PROJECT NO. PR-2021-005371
Application No. SD-2021-00186

Requesting final plat review for subdivision by lot line adjustment to formalize a subdivision by deed of Lots 5 and 6 of Ute Addition, with a waiver request for sidewalk width and waiver for right-of-way width for Ute Road NW

Re: Final Plat Review for Proposed Lots 5-A and 6-A, Ute Addition

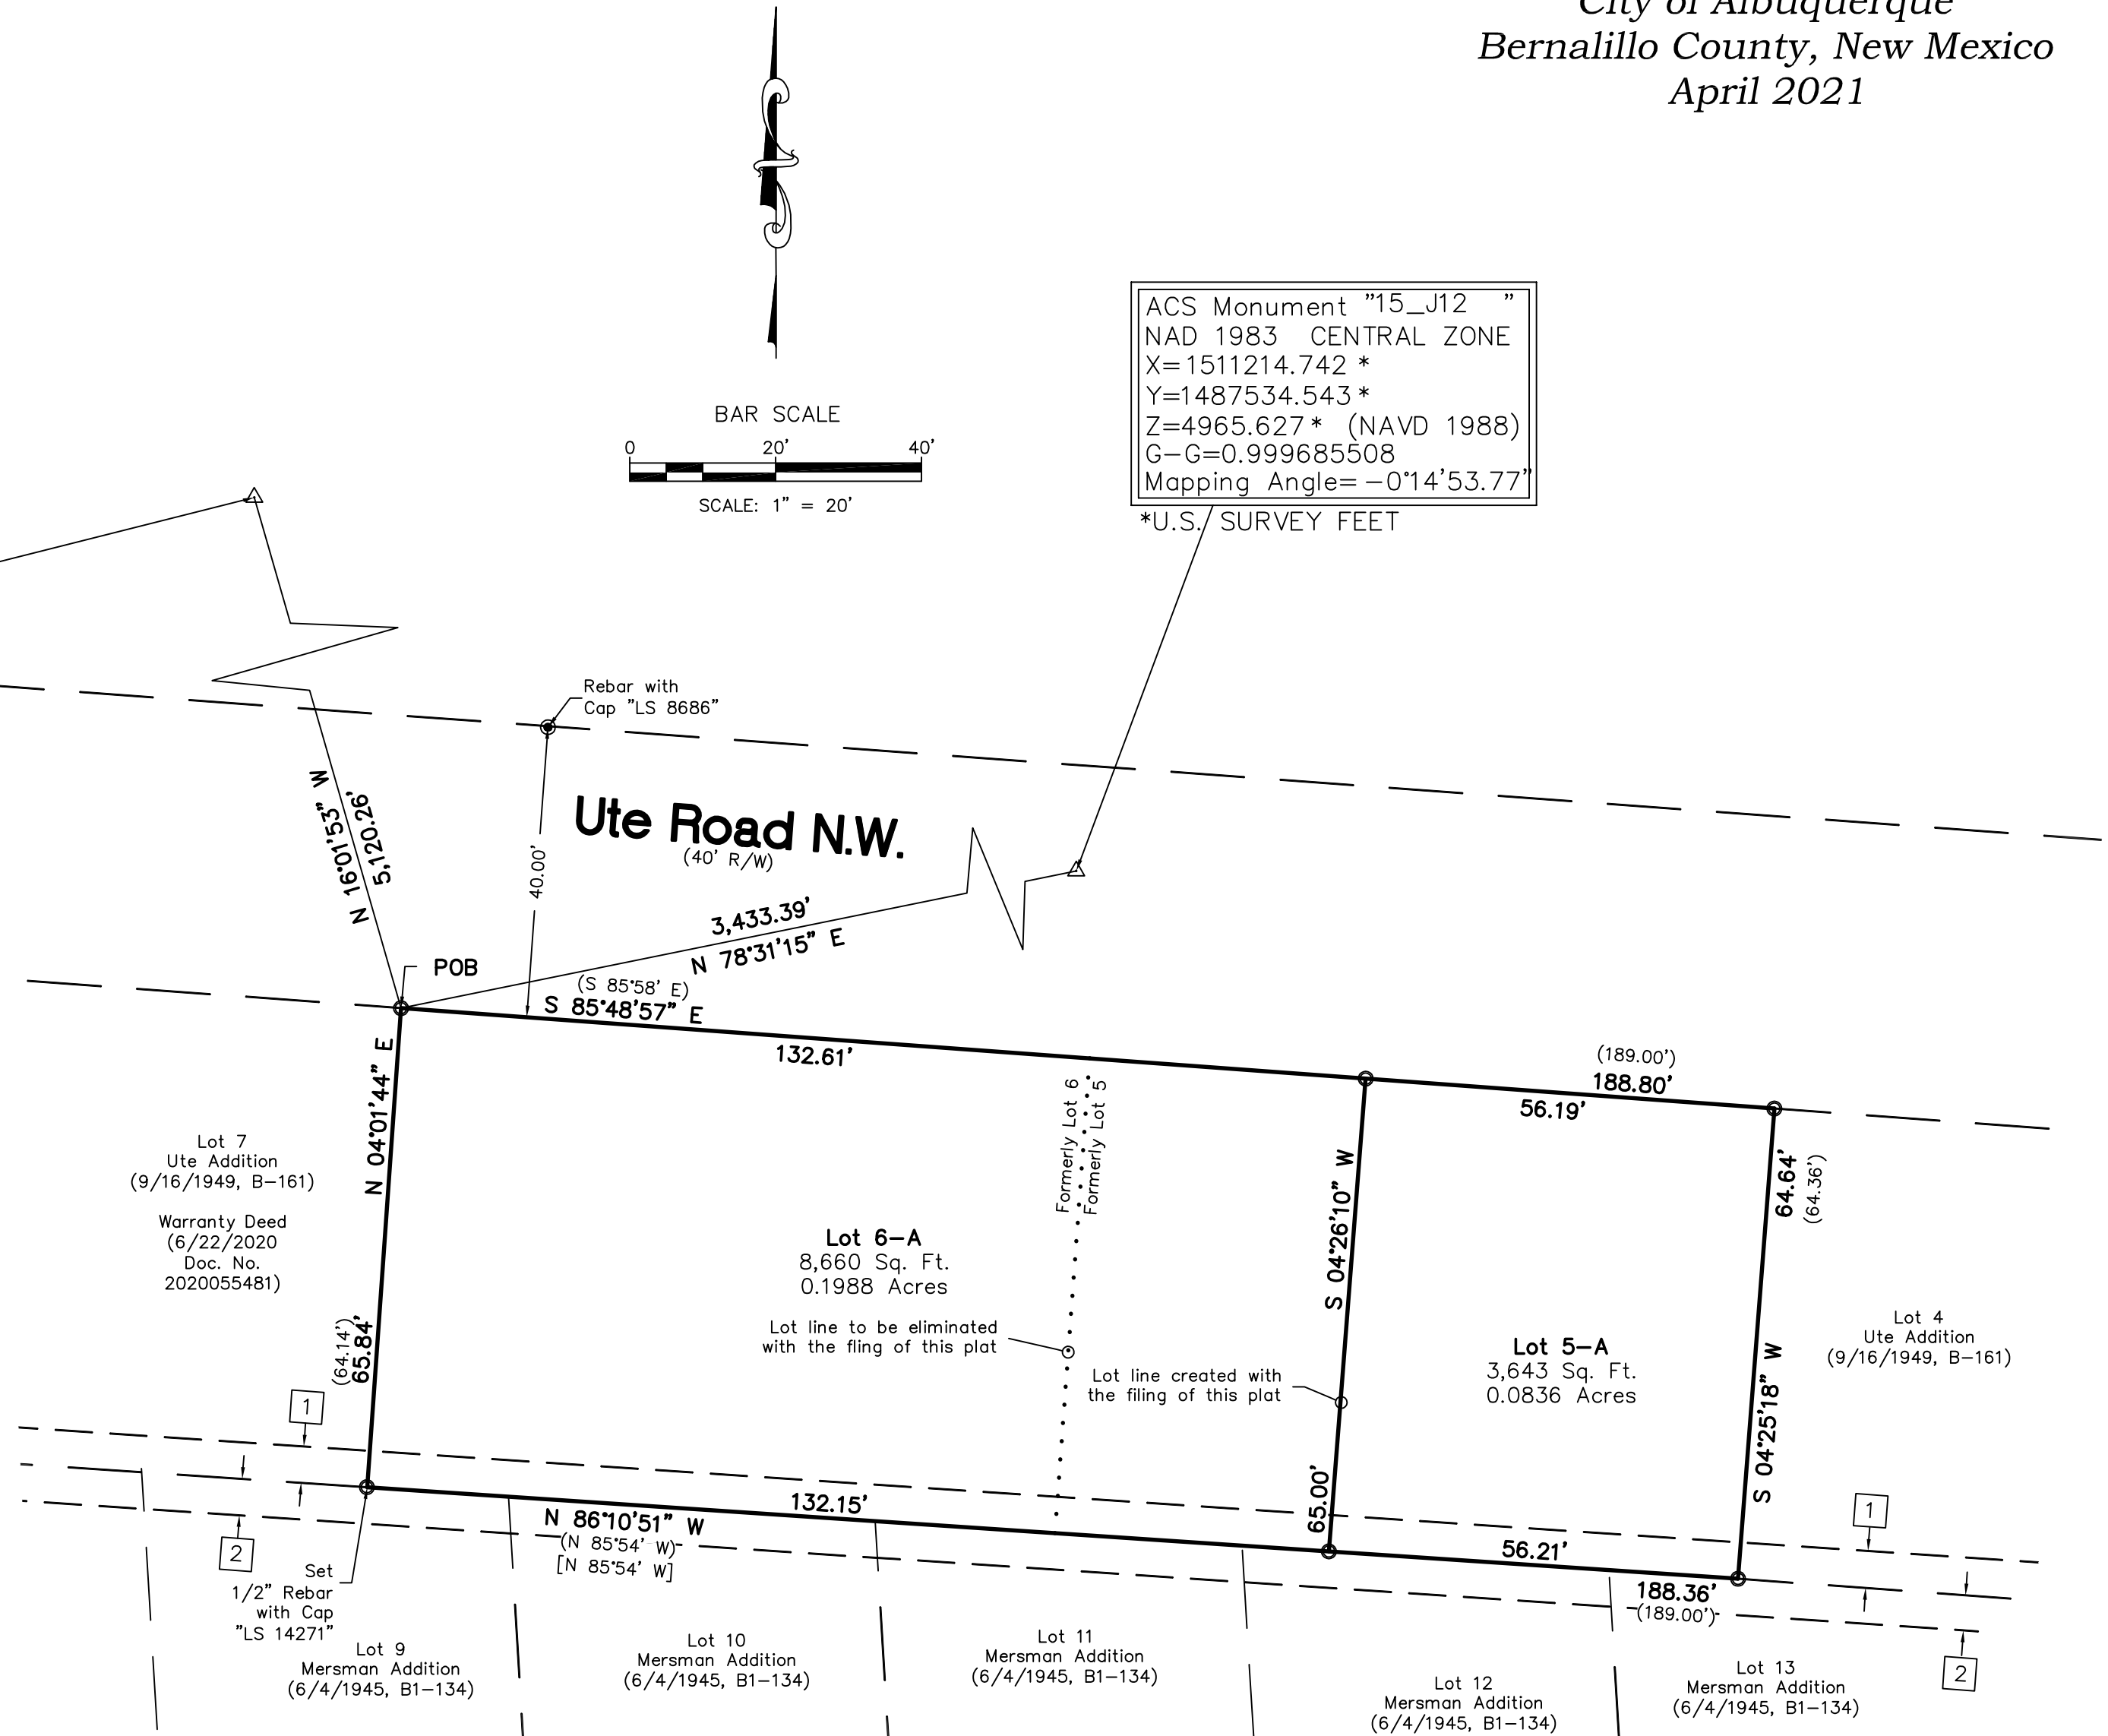
Add note to plat that a ZHE variance was granted for lot size.

Add note to plat that a ZHE variance was granted for setback.

Add notes to the plat that Staff determinations were made to allow existing sidewalk width of ROW width for Ute Road on plat.

Noted, ZHE variance was discussed at 9/15 hearing and noted on page 2 of the plat.

Noted, the ZHE variance and staff determination notes have been added to page 2 of the plat.

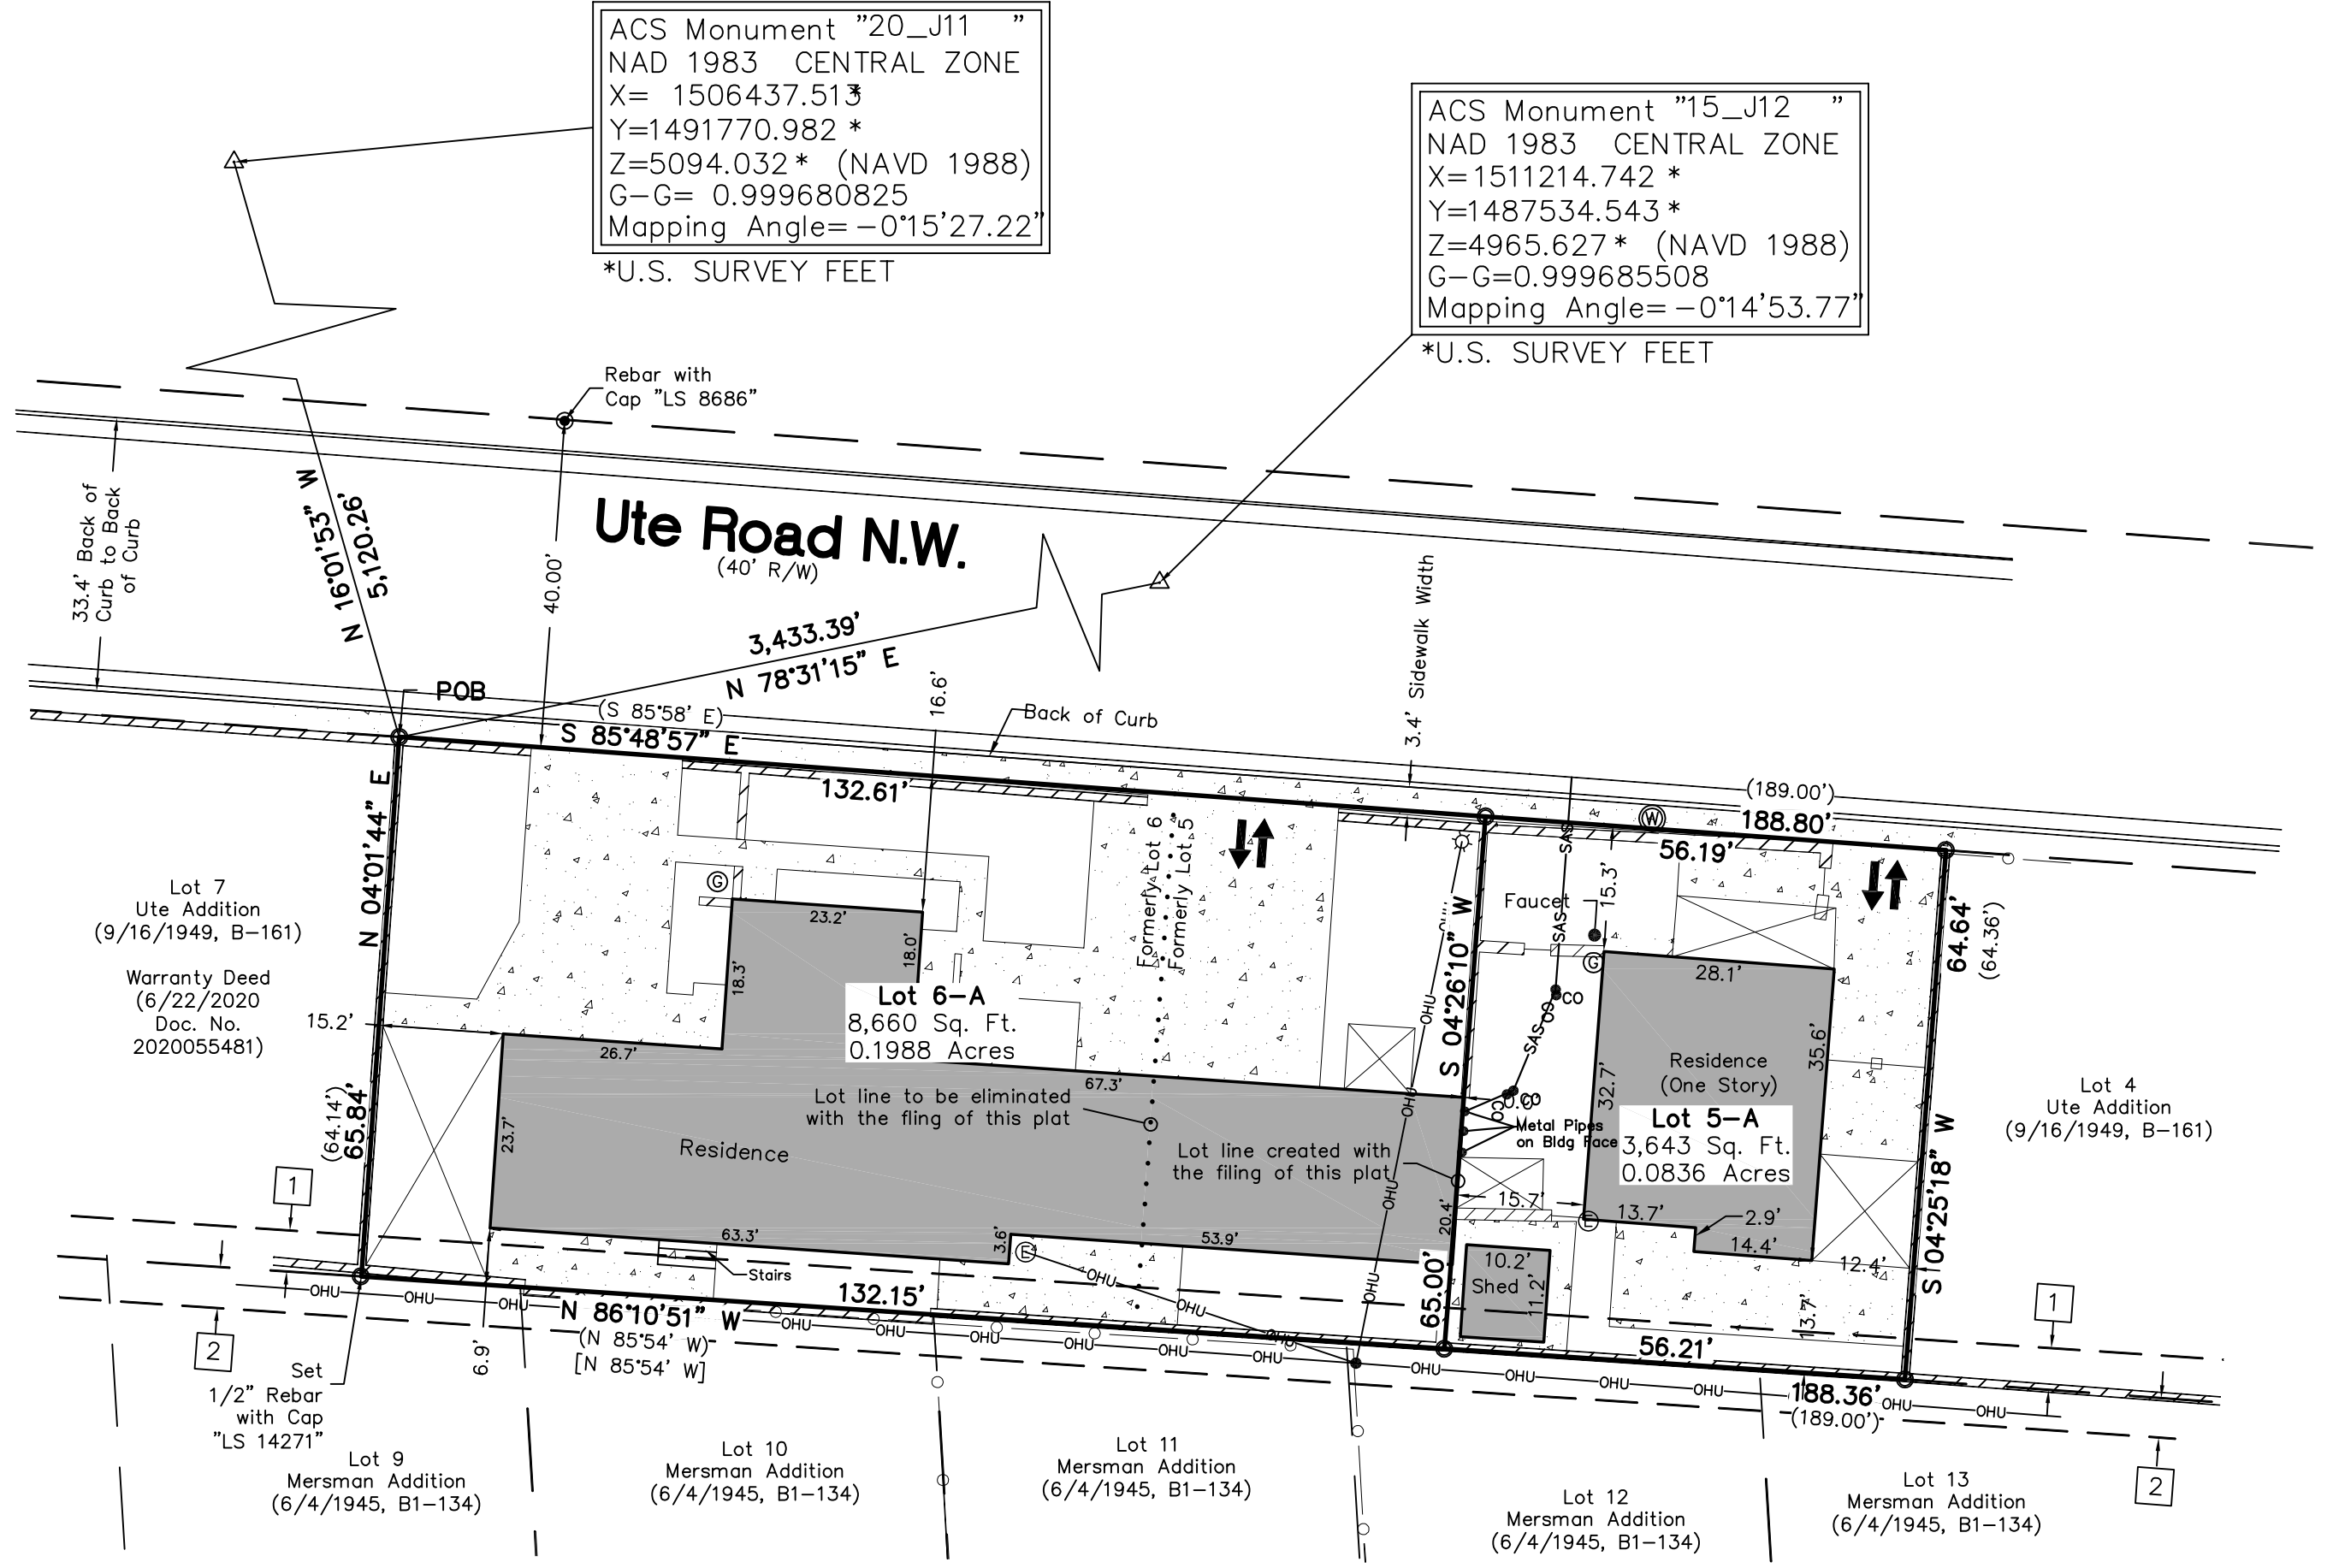
2. The walls along the front of the property line appear to fall within the sight distance triangles. Wall height should not be higher than 3 feet from the gutter. Modification of the wall is necessary prior to sign-off. (I do not see any additional information on these walls within the latest submittal package.)

Noted, the walls along the front of the Lot 6-A property are not out of compliance for the western driveway, but the walls for the driveway along the former lot line are out of compliance with sight triangle requirements by less than a foot. The walls for Lot 5-A are out of compliance by approximately a foot and a half.
